From: Martyn White <Martyn.White@arun.gov.uk>
Sent: 30 September 2019 16:53
To: Planning.Responses <Planning.Responses@arun.gov.uk>
Subject: BR/247/19/PL

BR/247/19/PL

Change of use & conversion of first & second floors from dwelling (C3 Dwelling houses) to 5 room HMO (C4 Houses in multiple occupation) with associated upgrades, additional rooflights, new WC, and new window to rear.

Proposed Elevations
JP Capital Ltd

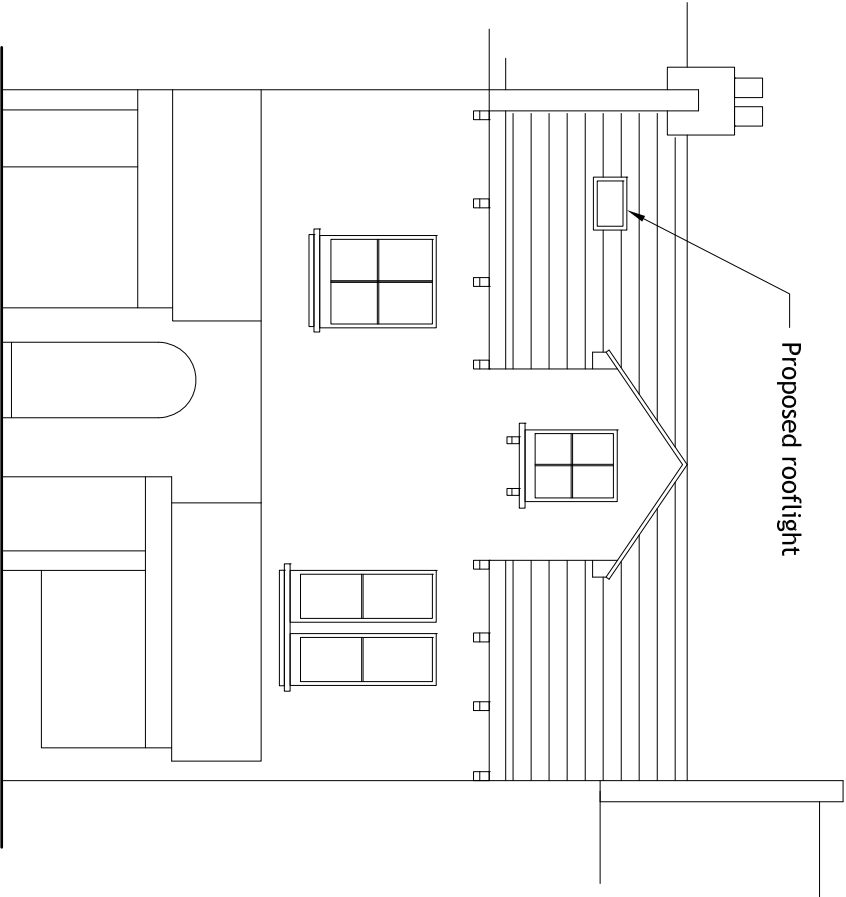
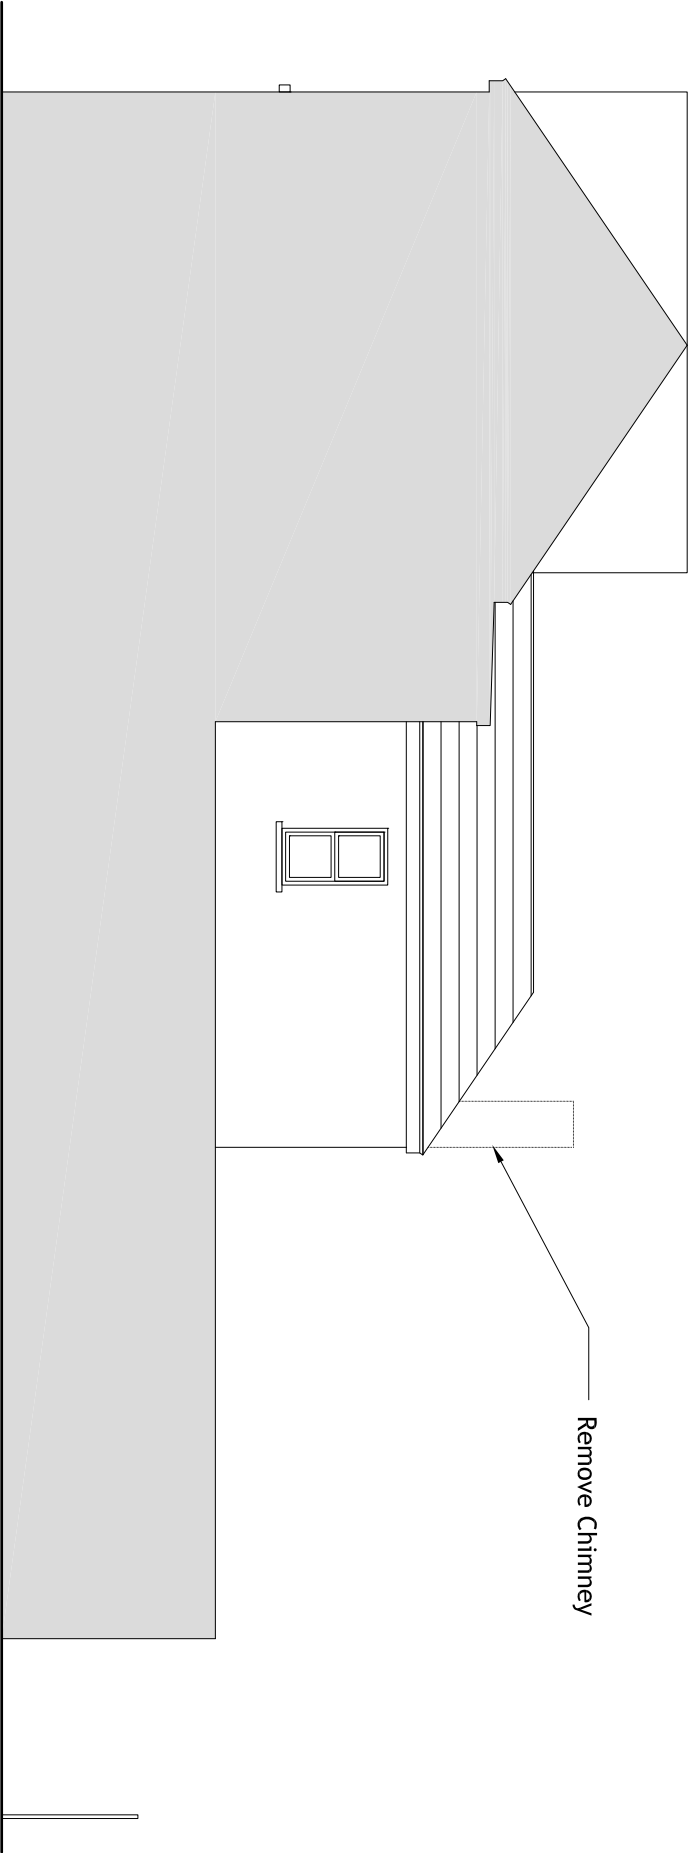
The proposed rooflight, whilst acceptable, should be of conservation standard with a central glazing bar. This issue should be conditioned if minded to approve the application.
